From: Barber, Robert [REDACTED]
Sent: 19 May 2015 09:56
To: Agency Dan McEwan
Cc: Neil Crowther
Subject: FW: FP/55/15/PL Site 6, Phases 4 & 5, Land North of Felpham PO22 8FX
Importance: High

The proposal is primarily for the change in density of residential dwellings from 23 x 5 bed and 5 x 5 bed to 38 x 4 bedroom dwellings. This change to density is unlikely to result in a significant increase in traffic accessing the site or using the local road network.

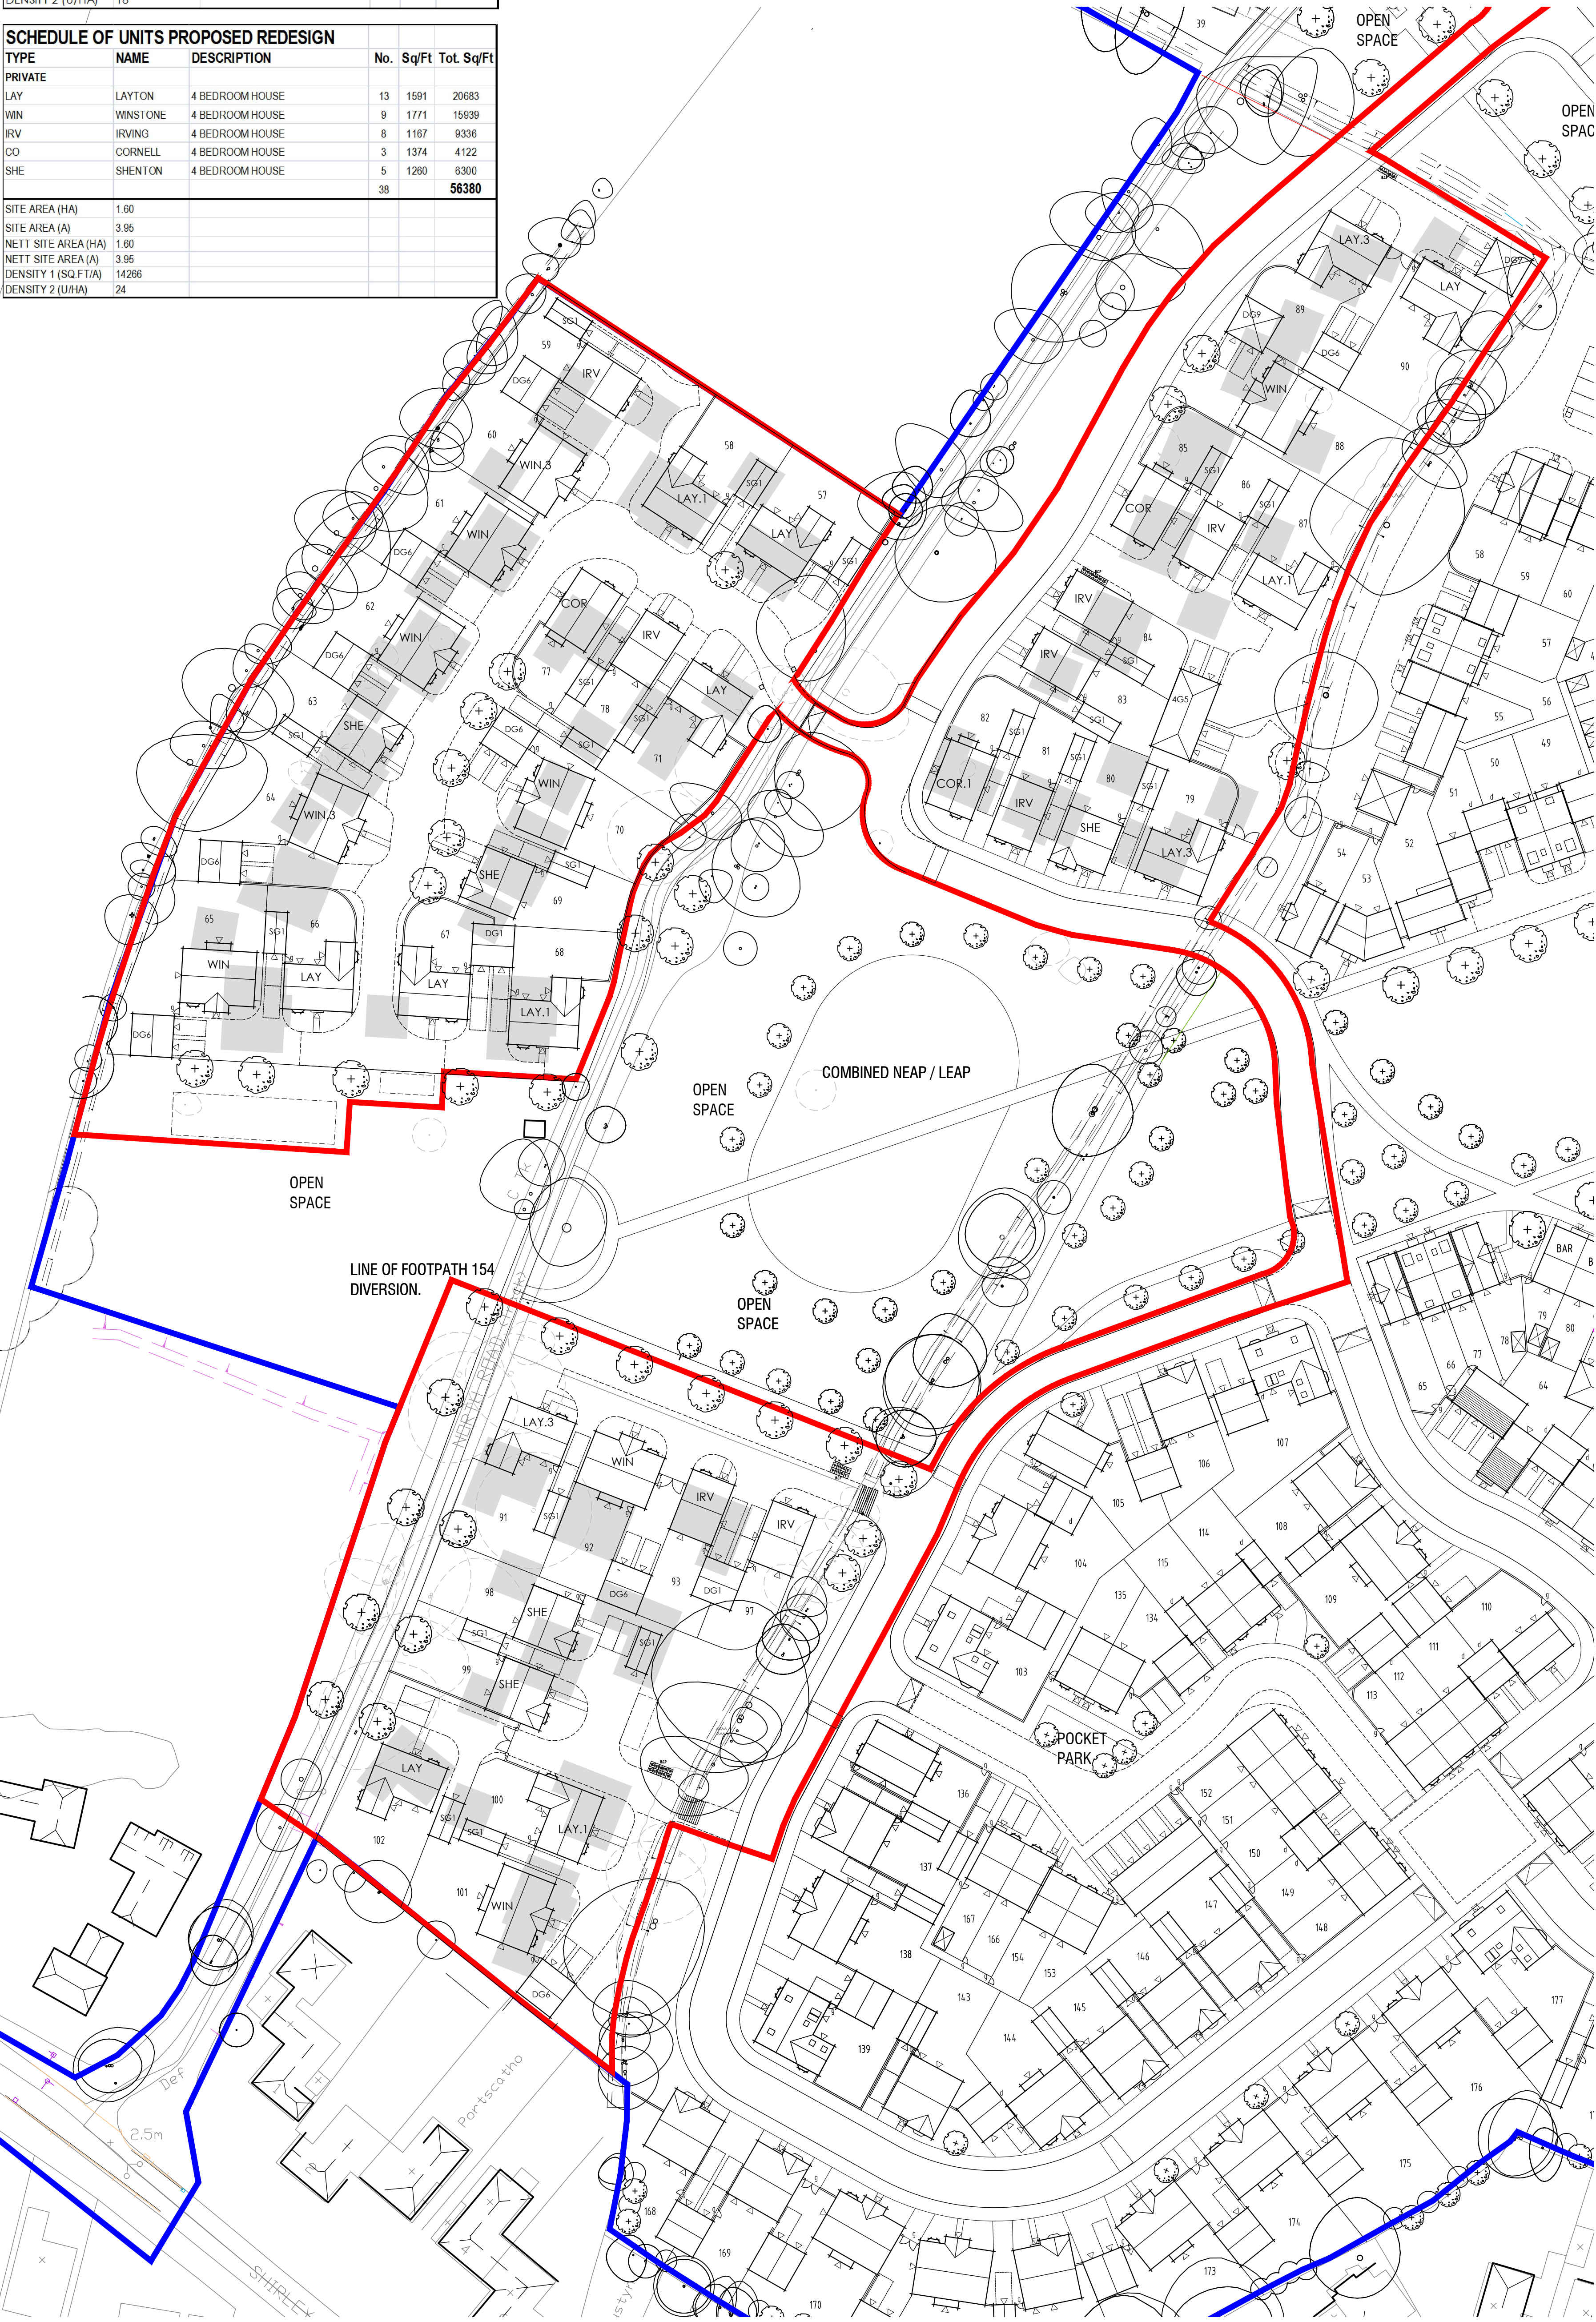
It would also be helpful if the applicant could provide a list/statement detailing the changes proposed as part of this proposal. In particular details of changes which will impact on the areas intended to be put up for adoption as public highway are required.

The changes are shown on the site plan and are also shown on the extract below. Generally the methodology behind the re-plan is to replace the large 3 storey detached units with smaller family homes which we already have an approval on site.

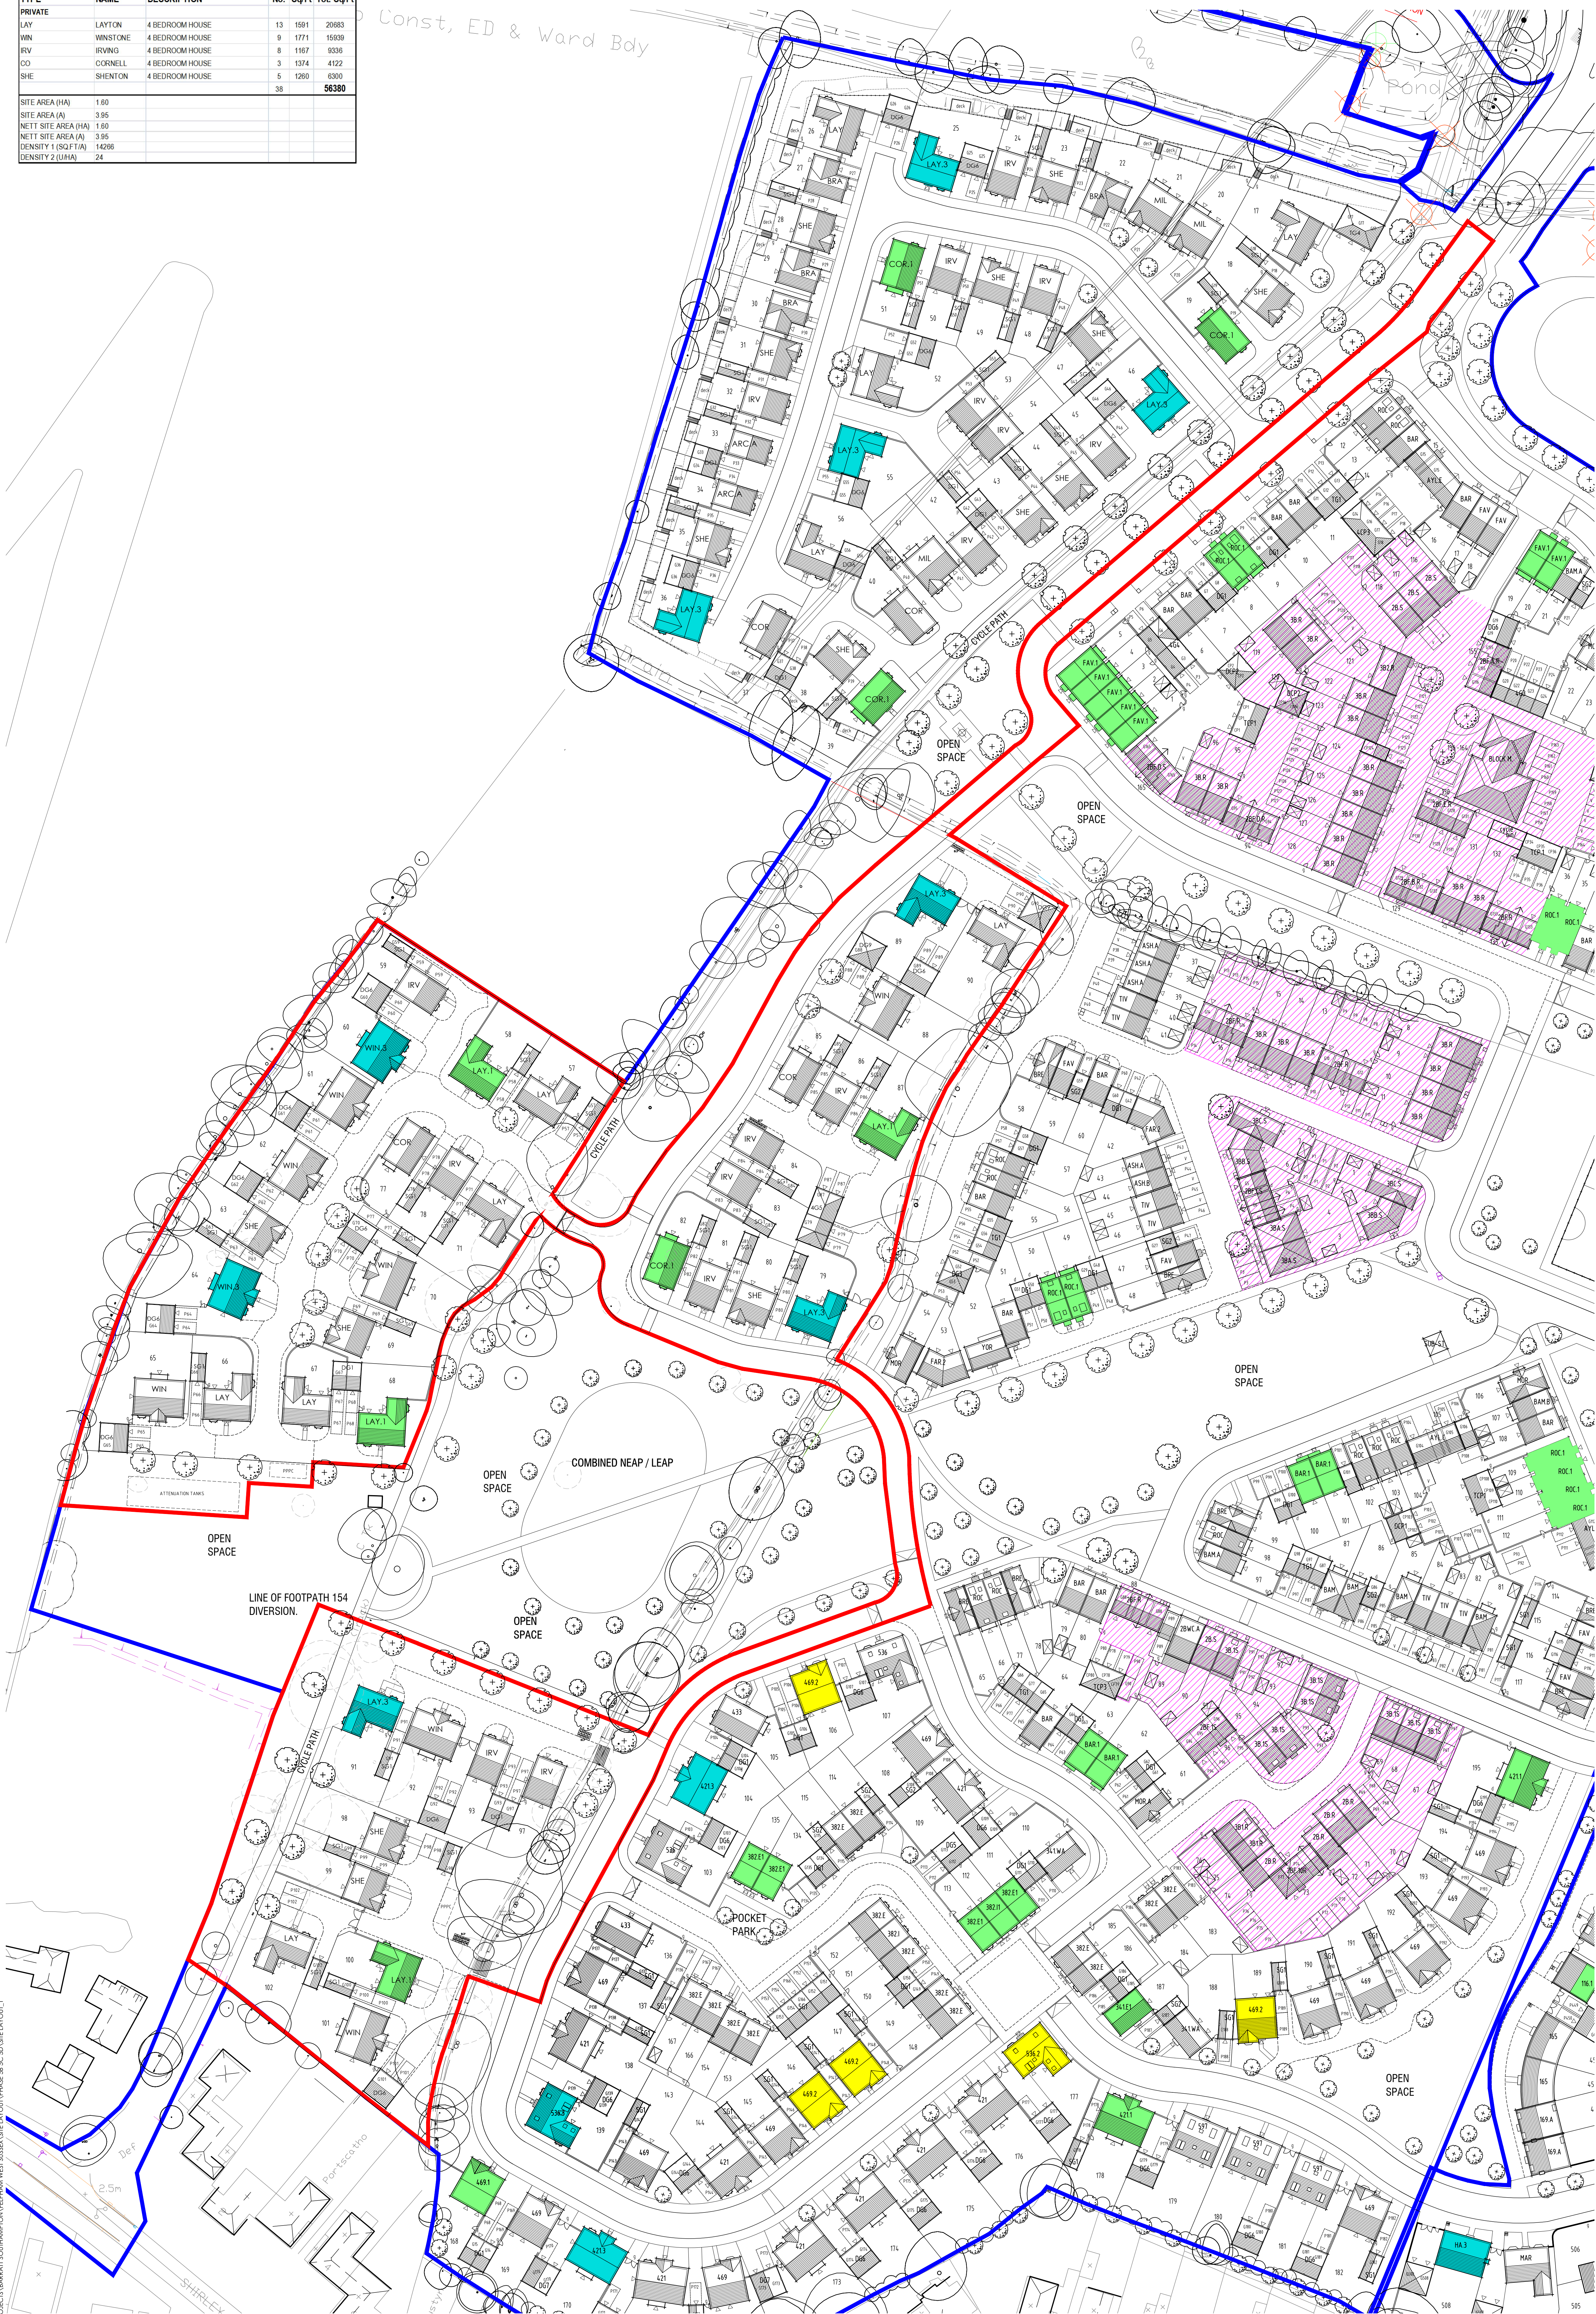
The submitted plans show the public highway within the red line, however there does not appear to be any changes to the approved road layout. Can the applicant please confirm there are no changes proposed to the design and construction of the road and footway layouts.

The application form states there are to be 114 parking spaces, however the Design and Access statement suggests there will be 88 (a decrease from the approved 91). Can the applicant please confirm the parking provision, on a plan to establish the level of parking overall and the provision proposed for each dwelling.

The Bognor – Barnham cycle route (secured through the outline consent) runs through the development (south/north), however this does not appear to be shown on the mapping provided, can the applicant ensure it is included, and labelled, on the planning drawing.

There is no change to the road or footways. The redline shows the application up to the nearest adopted highway.

This was a typo in the D&A which has been rectified. All plots have a garage plus 2 no parking spaces. 114 total.

Now labelled on the site plan.
